Our Ref: ID 2728  
Your Ref: SSD-65595459

**Environmental Impact Assessment for Hunter Indoor Sports Centre (HISC) SSD-65595459**

Elspeth O'Shannessy  
Manager Emergency Risk Assessment  
**NSW State Emergency Service**

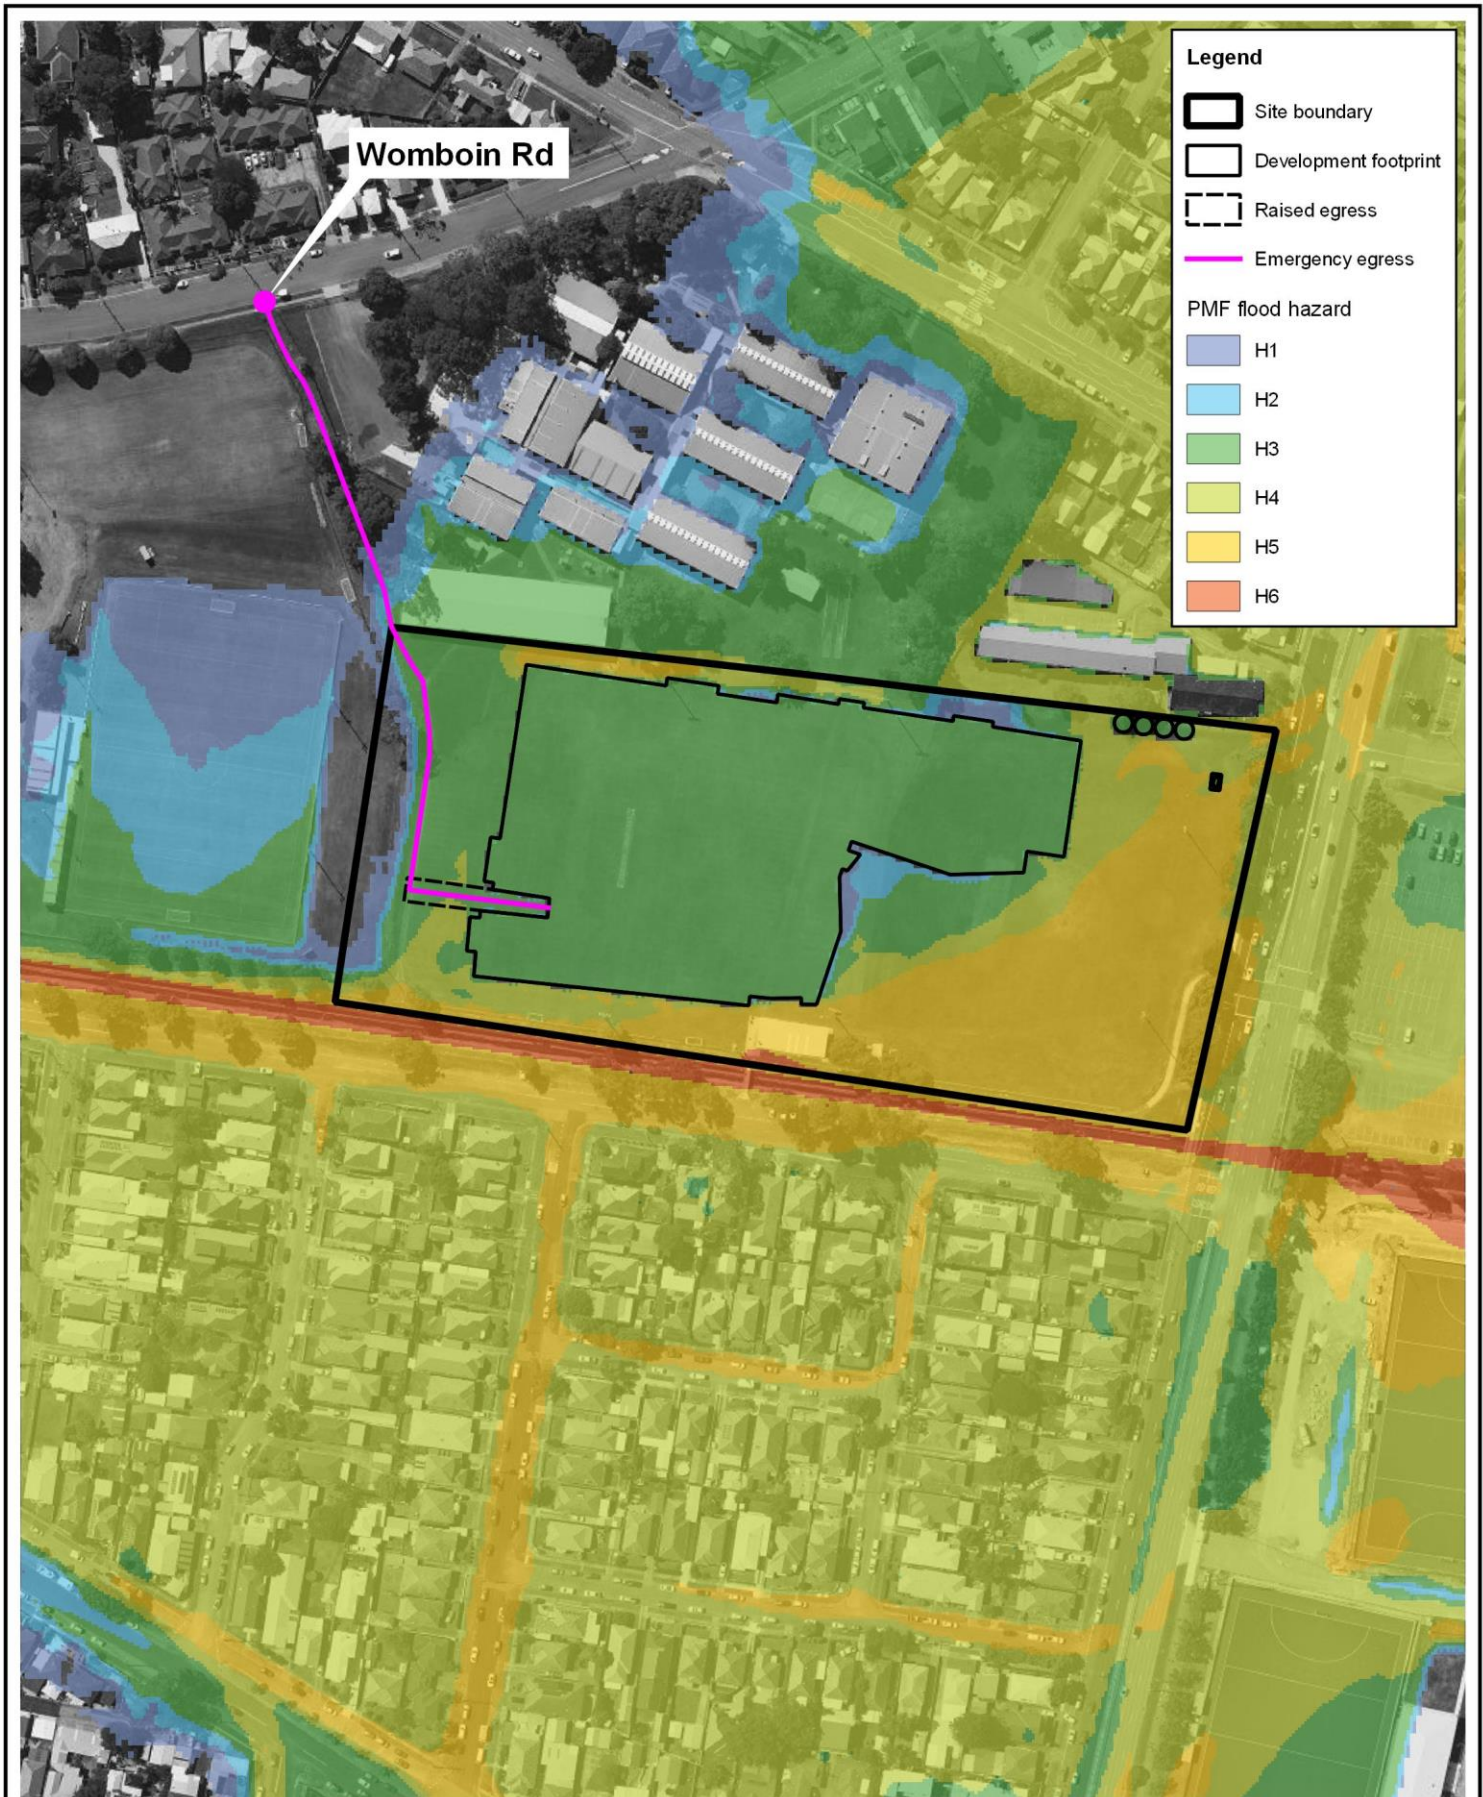
The Flood Emergency Response Strategy provided includes a proposed evacuation route which is accessible only on foot and by traversing H3 flooding during the PMF event<sup>9</sup>. It is unacceptable, as the primary evacuation strategy, to expect people to escape from a flood on foot (also referred to as overland escape/overland access), especially with the high likelihood of ongoing poor weather conditions and should not be used to justify the development. Pedestrian evacuation is a backup strategy. We recommend the preferred emergency response should be to close the facility early on early if there is a risk of flooding, on receipt of advice from the Bureau of Meteorology.

The Emergency Response Strategy further states *“The flood hazard condition during the peak of the PMF event is H3, which is suitable for wading by adults. This will enable access to the building by emergency services personnel, if required and/or to evacuate people from the Site<sup>10</sup>.”* While this level of hazard may be below the recommended working limit for trained adults<sup>11</sup>, it is unacceptable as a primary response strategy to expect SES personnel to wade through flood water. NSW SES has historically attended incidents relating to flooding, including people trapped in vehicles along Turton Road and flooding on Monash Road.

- **Recommend** closing the site early if there is a risk of flooding, on receipt of advice from the Bureau of Meteorology (BoM), or when other evidence leads to an expectation of flooding, as a primary emergency management strategy.
